Accessibility Design Statement – S75W

Project Title: Proposed Residential Development
Avon Road & Beechworth Road, Pymble

Date: 18 August 2016

Report Version: ADS(S75W)5278_v1.1

DRAWING TITLE			
HERITAGE _ PROPOSED LOWER LEVEL			
SCALE	DATE	DRAWN	CHECKED
1:200 @ A3	01.11.2012	PS	JB
JOB	DRAWING	REVISION	
12009	MP 52.04	W

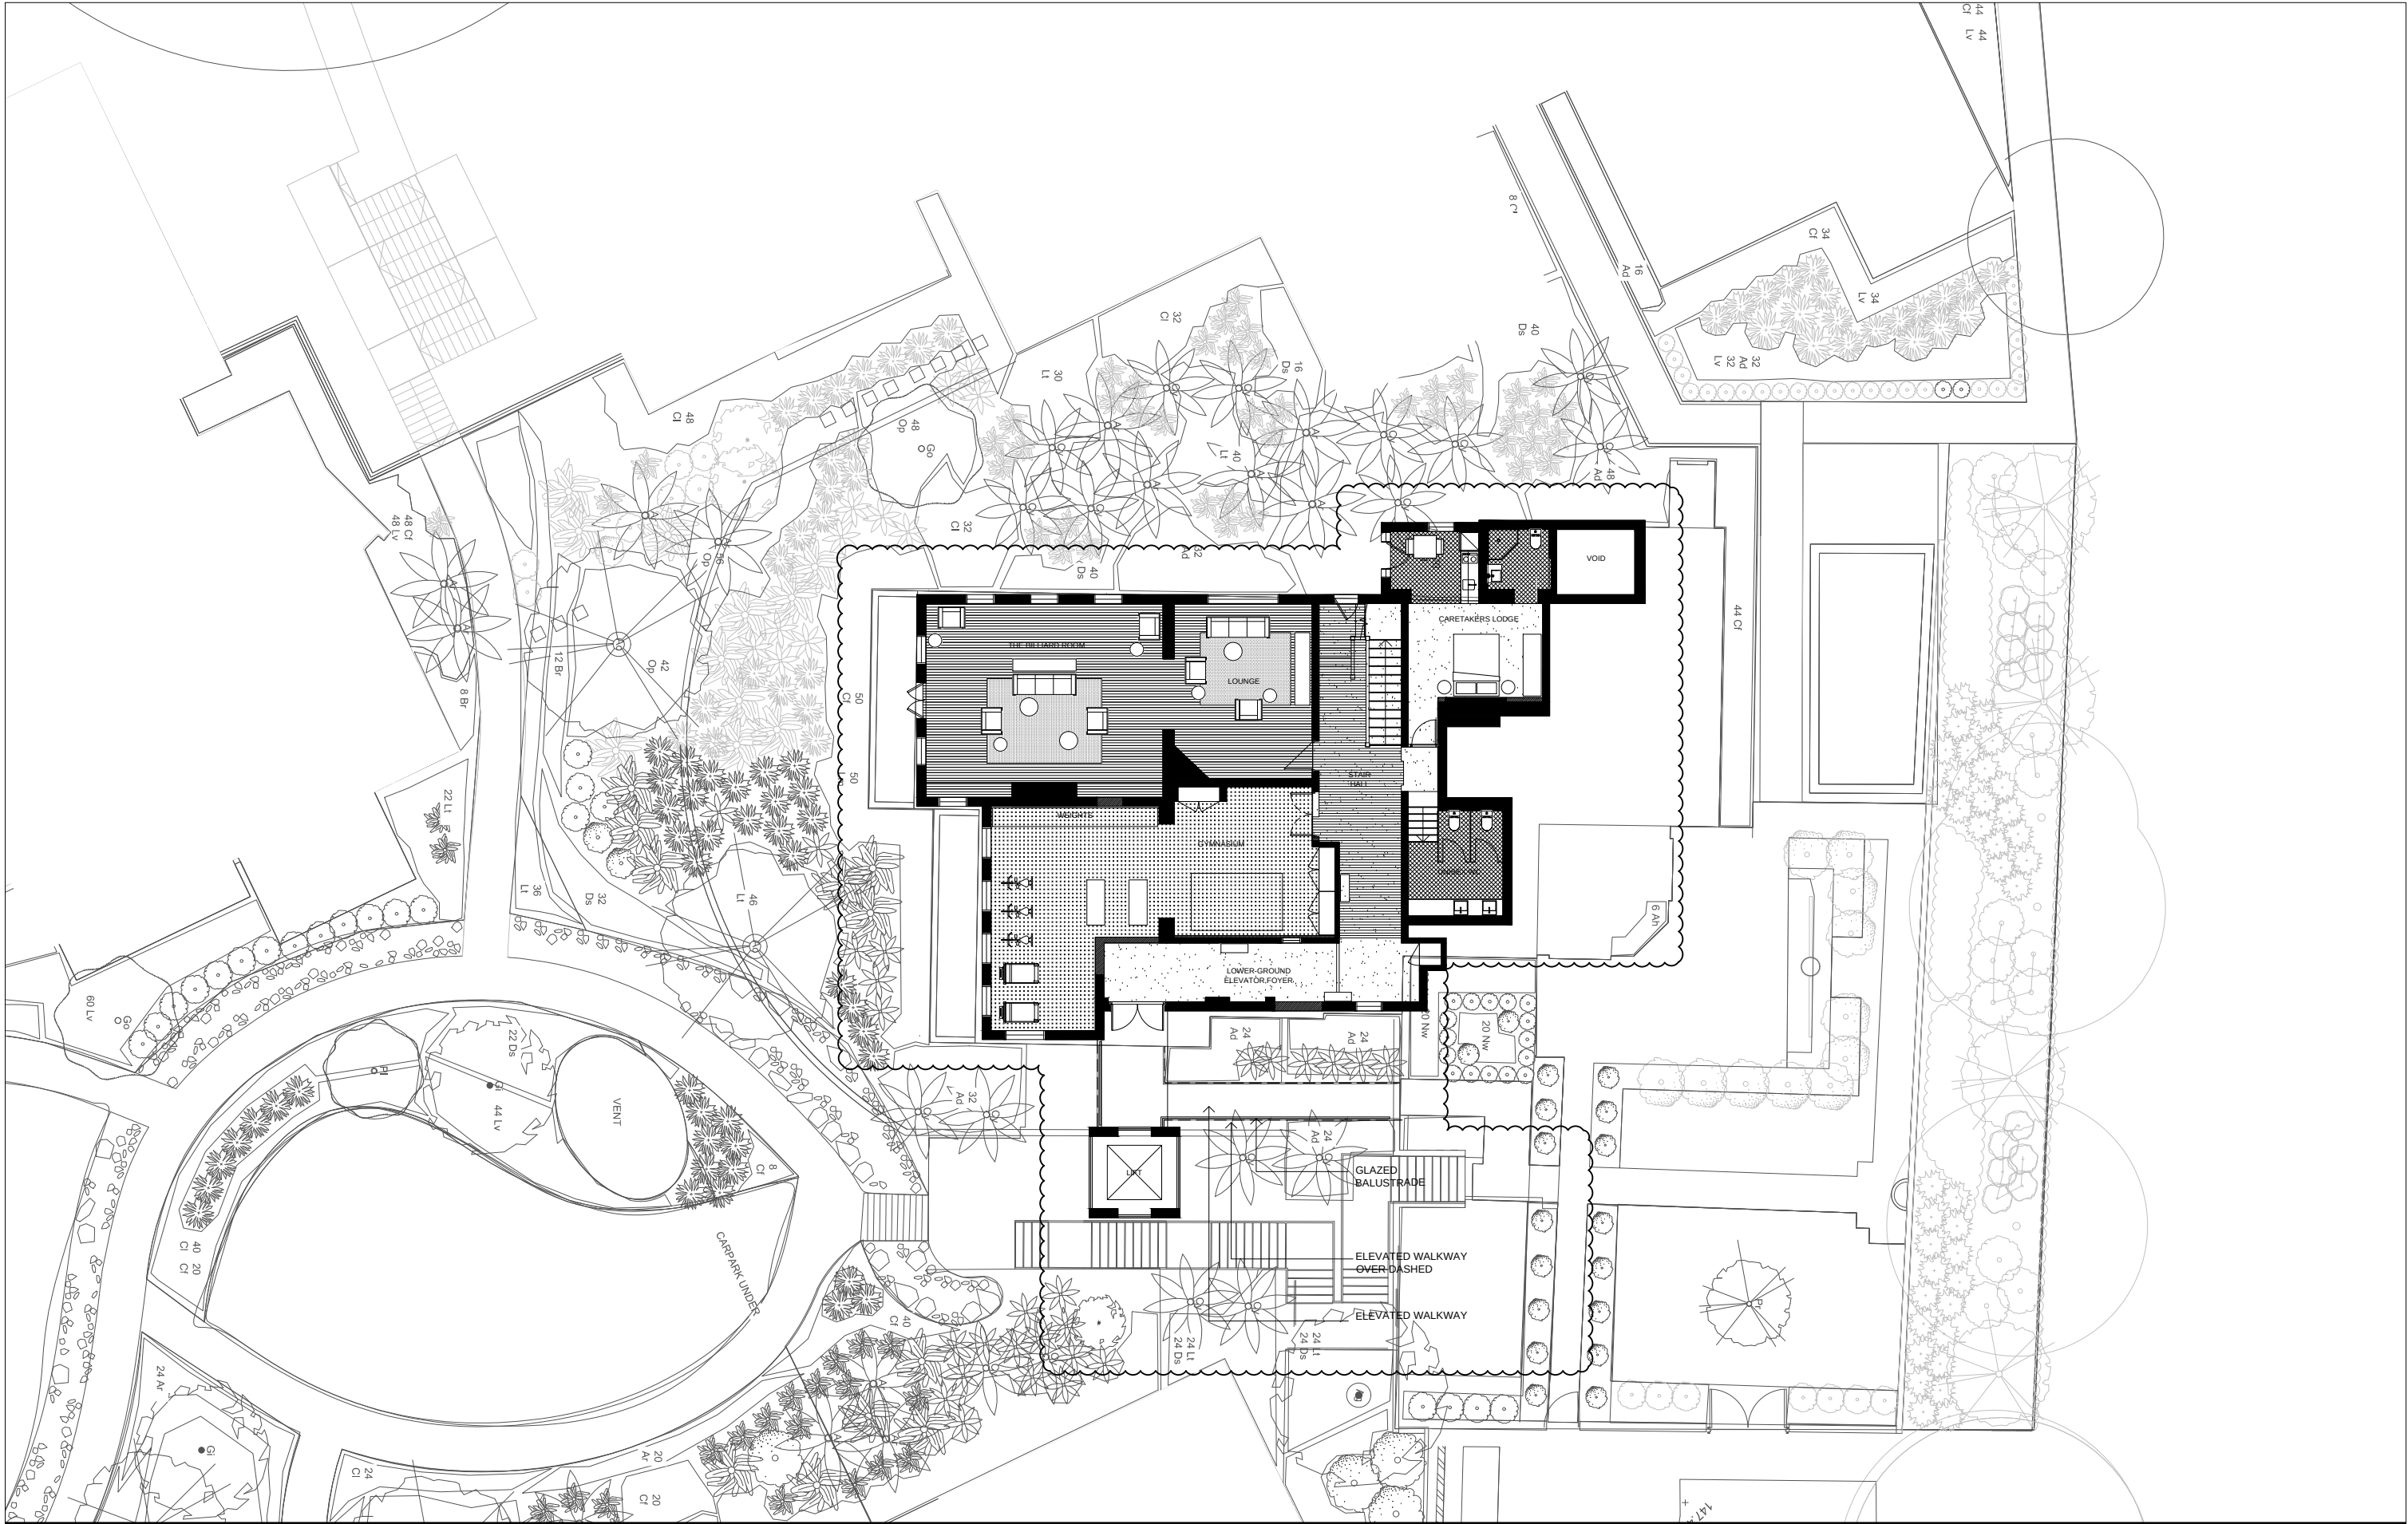
Doorways within the heritage building are to be further reviewed at detail design stage to either achieve compliance with requirements of AS1428.1-2009 or addressed via a performance solution report.

Internal stairways located within the heritage building are capable of being installed with accessible features required by AS1428.1-2009 including handrails, TGSIs and non-slip/luminance contrast nosings or addressed via a performance solution report.

An internal and external lift passenger lift combination at the “heritage House” is proposed as part of the common area of the development. The proposed passenger lift is to achieve compliance with Clause E3.6 of the BCA and AS1735.12.
